Addendum No. 1

RE: Contract # C204426

Rowan County (U-5738)

SR-2528 (JULIAN RD) FROM SR-2667 (SUMMIT PARK DR) TO US-601
(JAKE ALEXANDER BLVD) IN SALISBURY

Drawing file: 260 Signal Plans / 260_001_U-5738 tsh.pdf

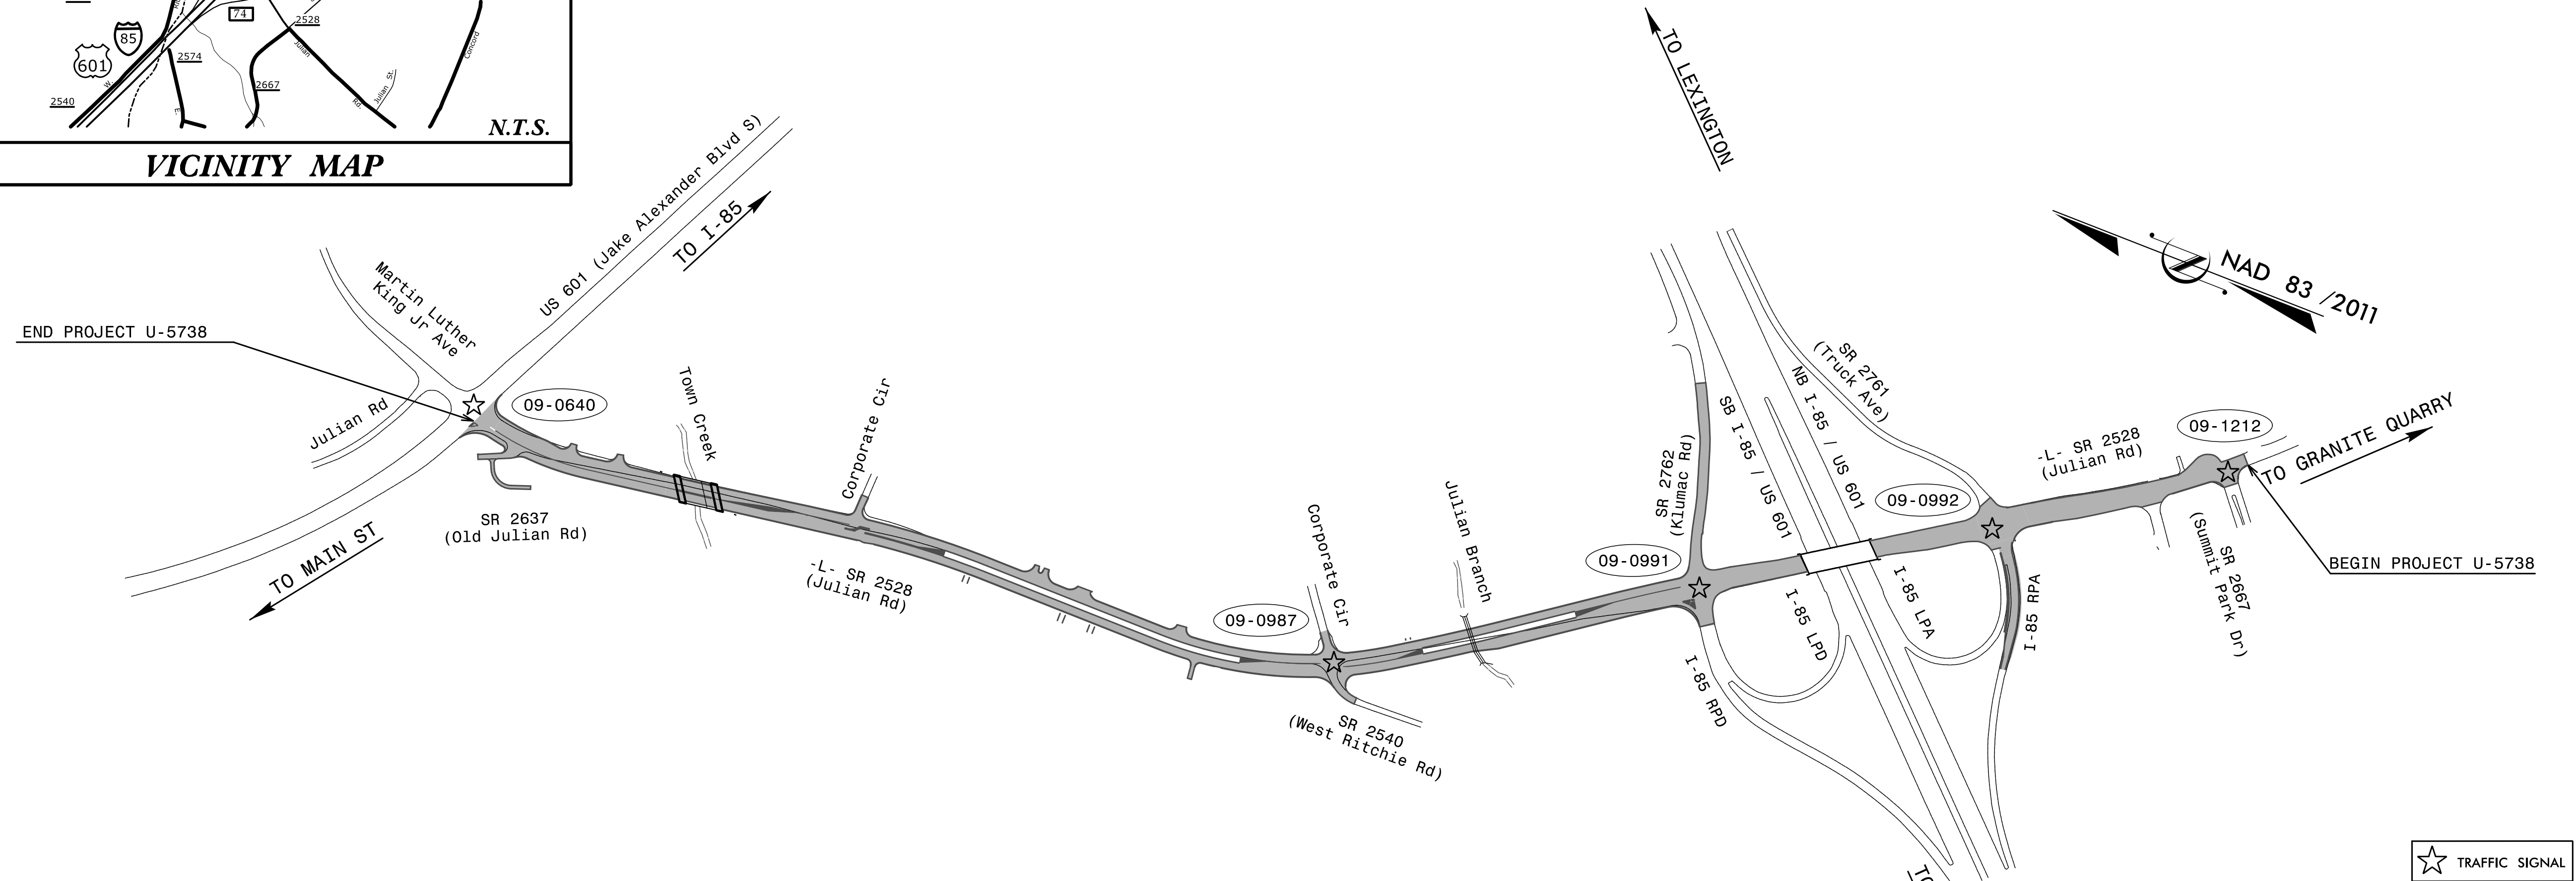
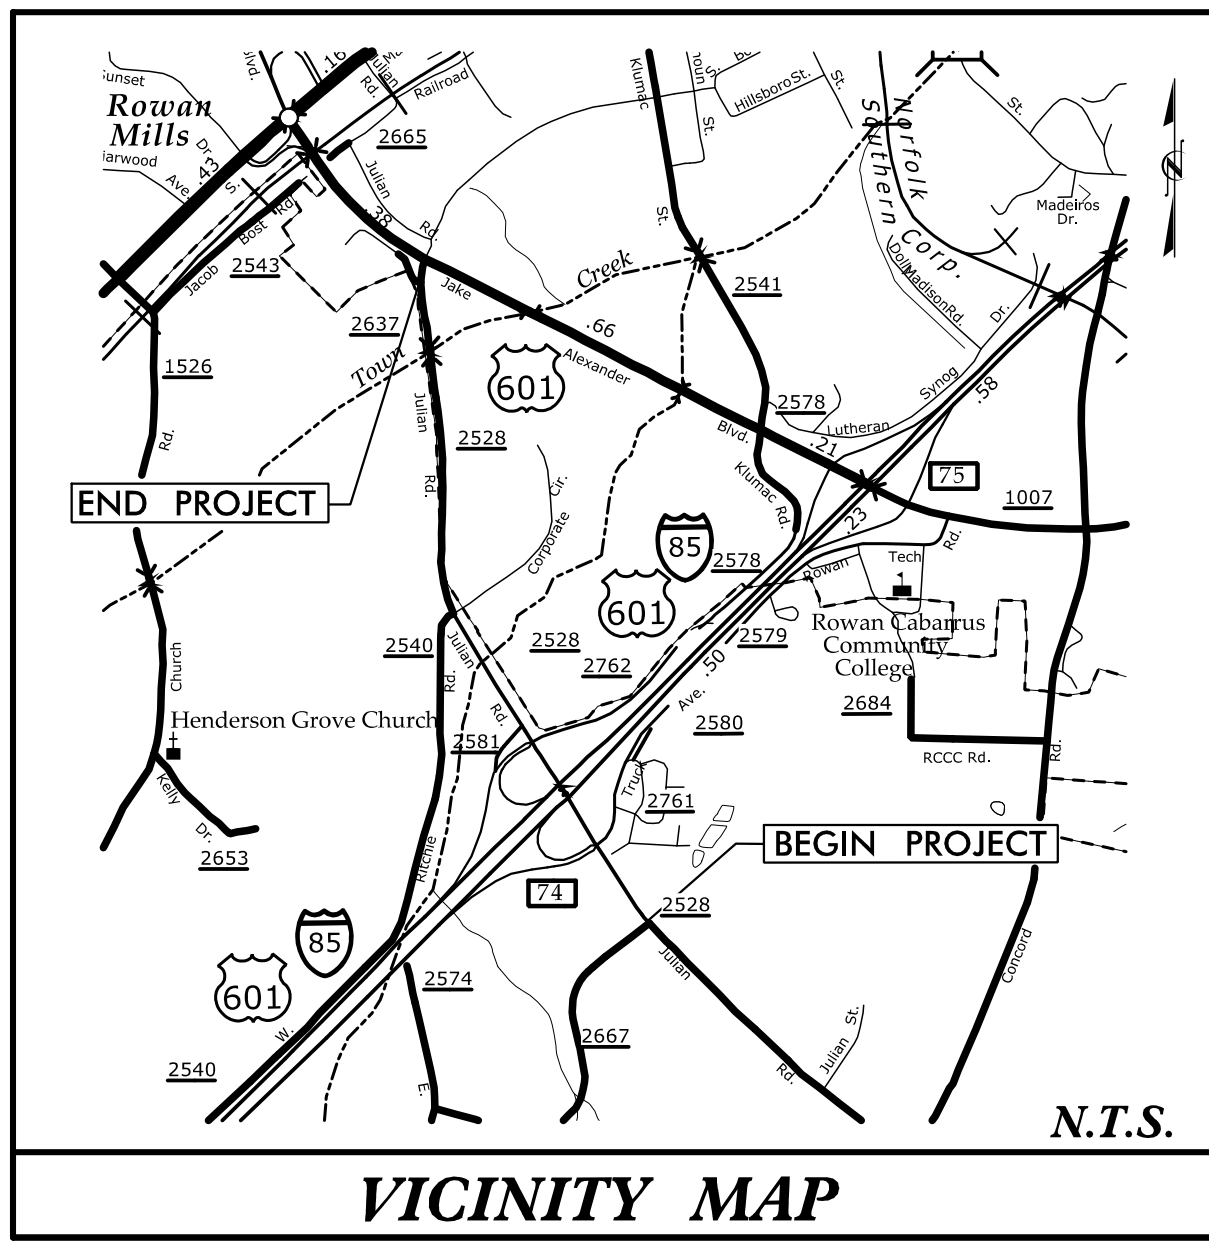
Sheet No.	Revision
Sig 1.0	Modified to reflect elimination of sheet Sig. 11.9 (now only goes to 11.8)
Sig 9.0	Signal head 51 changed from 4-section FYA to 3-section left protected only; Phasing revised accordingly for phase 5 and also to include Alt Phasing for Phase 1
Sig 9.1	Now changed to 2 nd sheet of Temp 1 Signal plan to include Alt Phasing addition
Sig 9.2-Sig 9.3	Modified Electrical Details for Phasing changes
New Sheets Sig 9.4-9.6	Sheets added as part of modified Electrical Details for Phasing changes
Sig 10.0	Signal head 51 changed from 4-section FYA to 3-section left protected only; Phasing revised accordingly for phase 5 and also to include Alt Phasing for Phase 1
Sig 10.1	Now changed to 2 nd sheet of Temp 2 Signal plan to include Alt Phasing addition
Sig 10.2-10.3	Modified Electrical Details for Phasing changes
New Sheets Sig 10.4-10.6	Sheets added as part of modified Electrical Details for Phasing changes

Drawing file: 260 Signal Plans / 260_205_090992-20211203e1-t.pdf

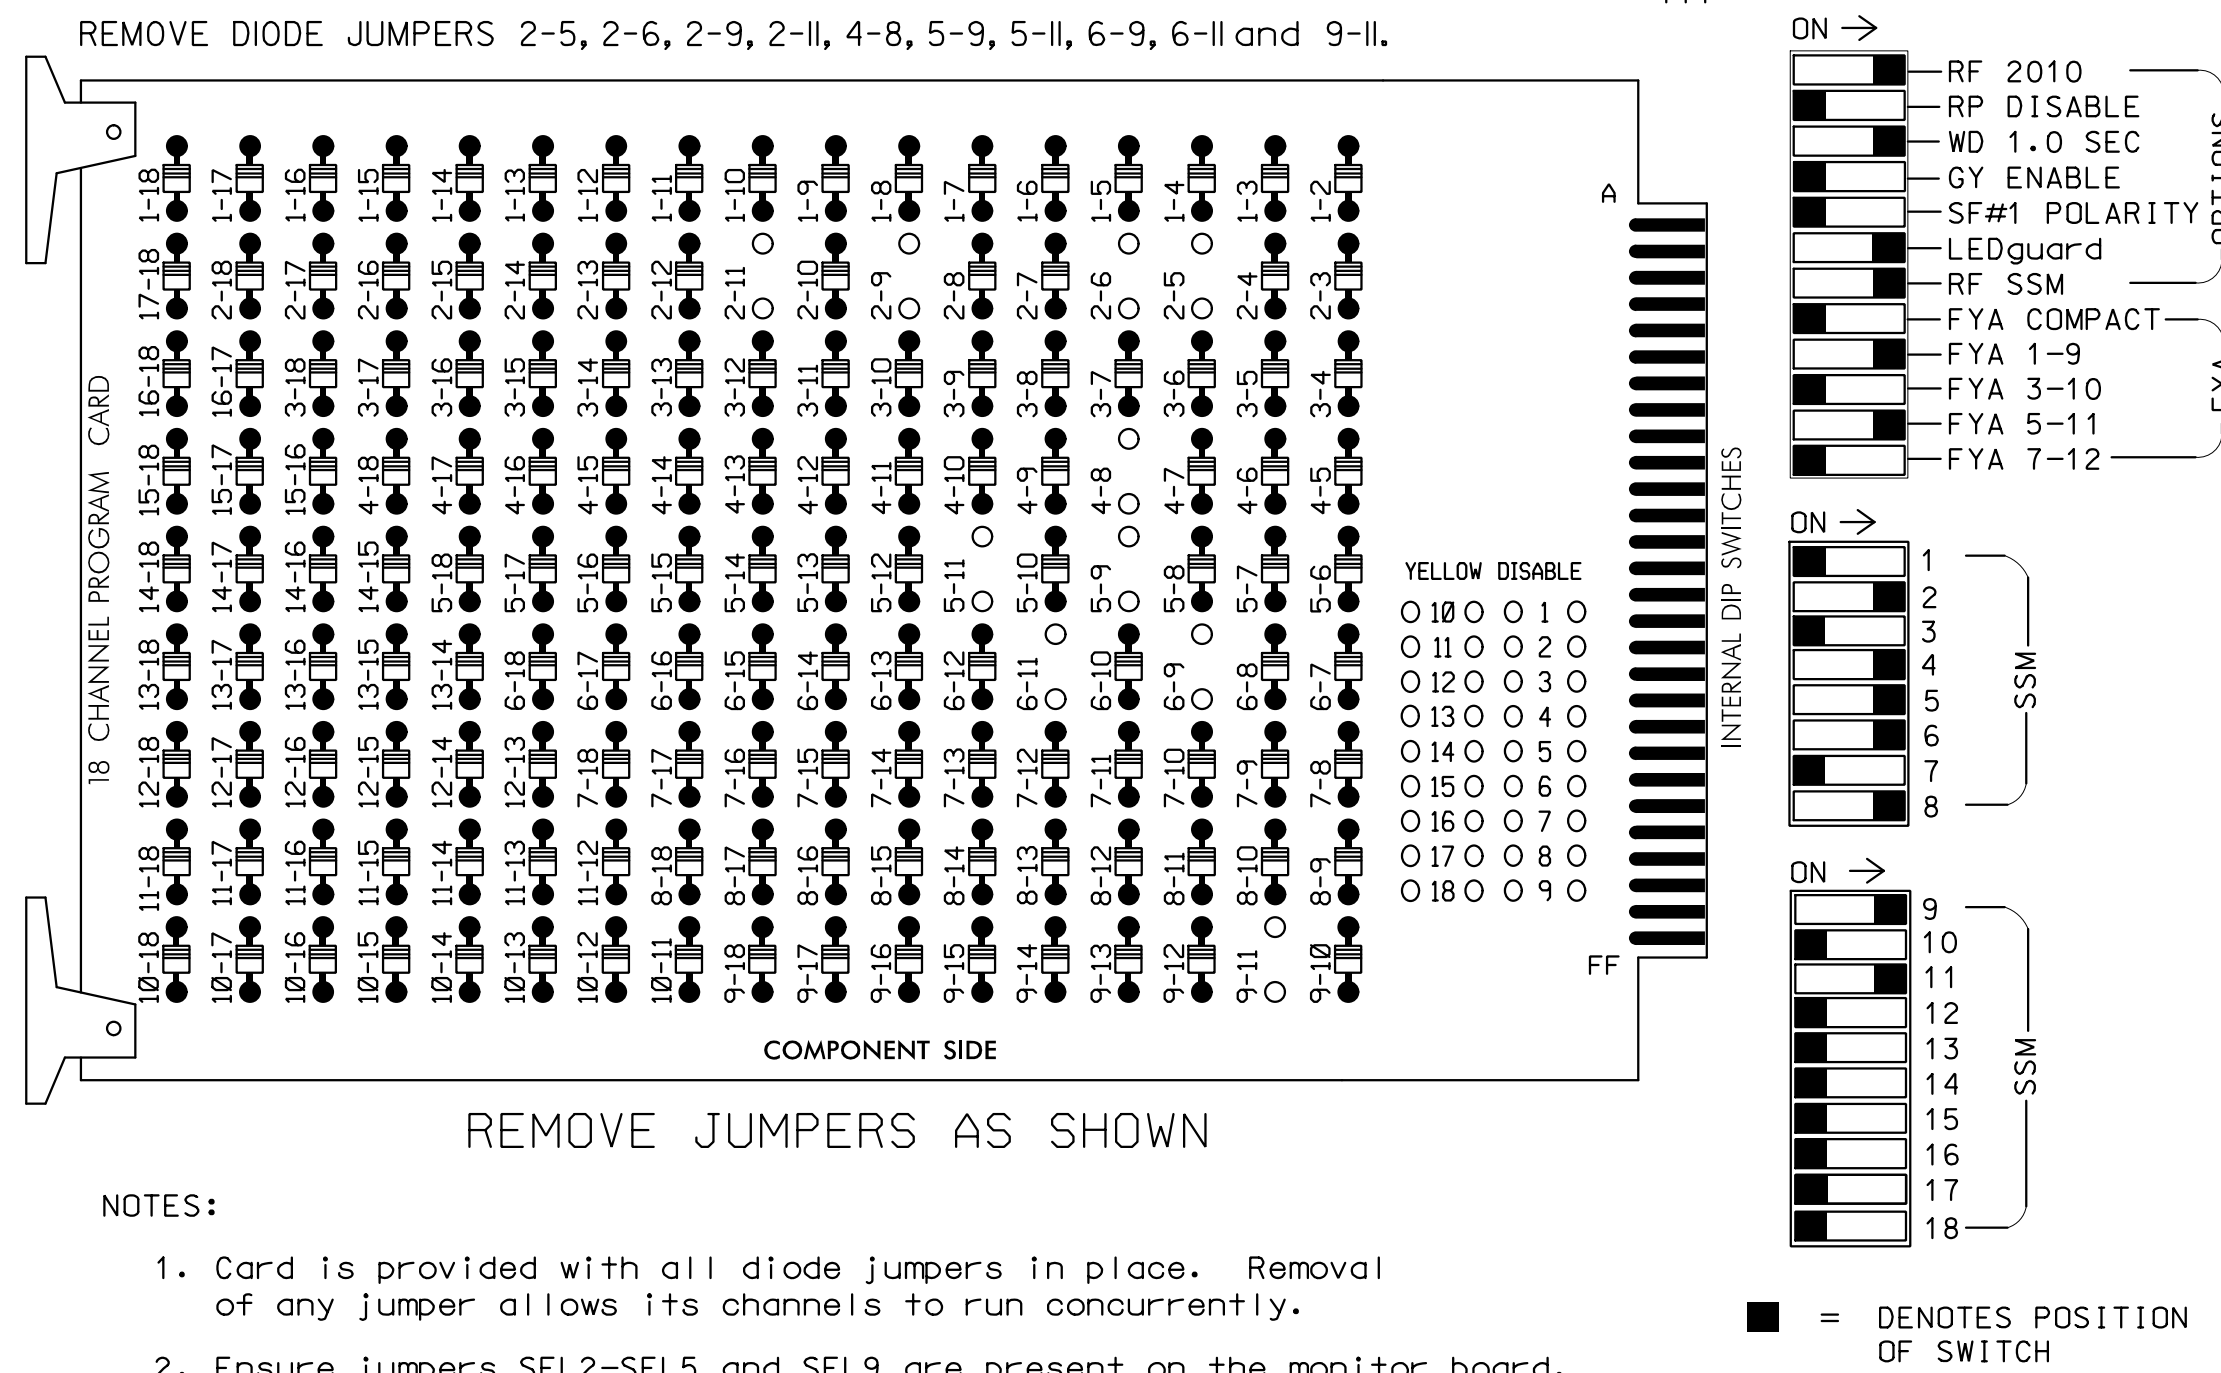
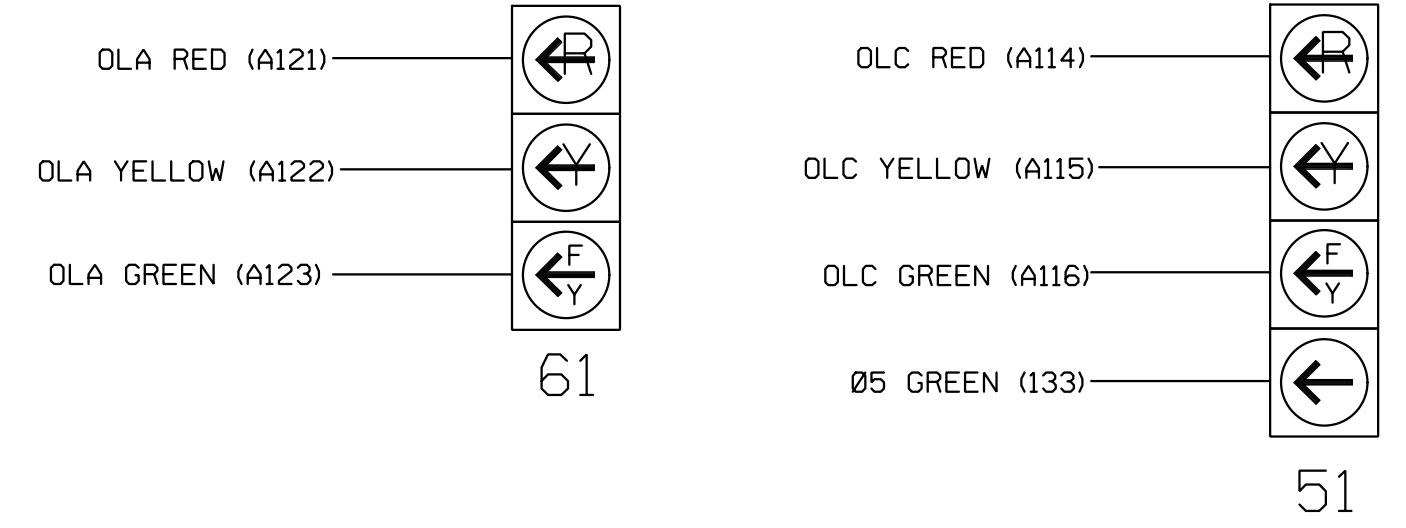
Sig 11.0-11.1	Signal head 51 changed from 4-section FYA to 3-section left protected only; Phasing revised accordingly for phase 5 and also to include Alt Phasing for Phase 1
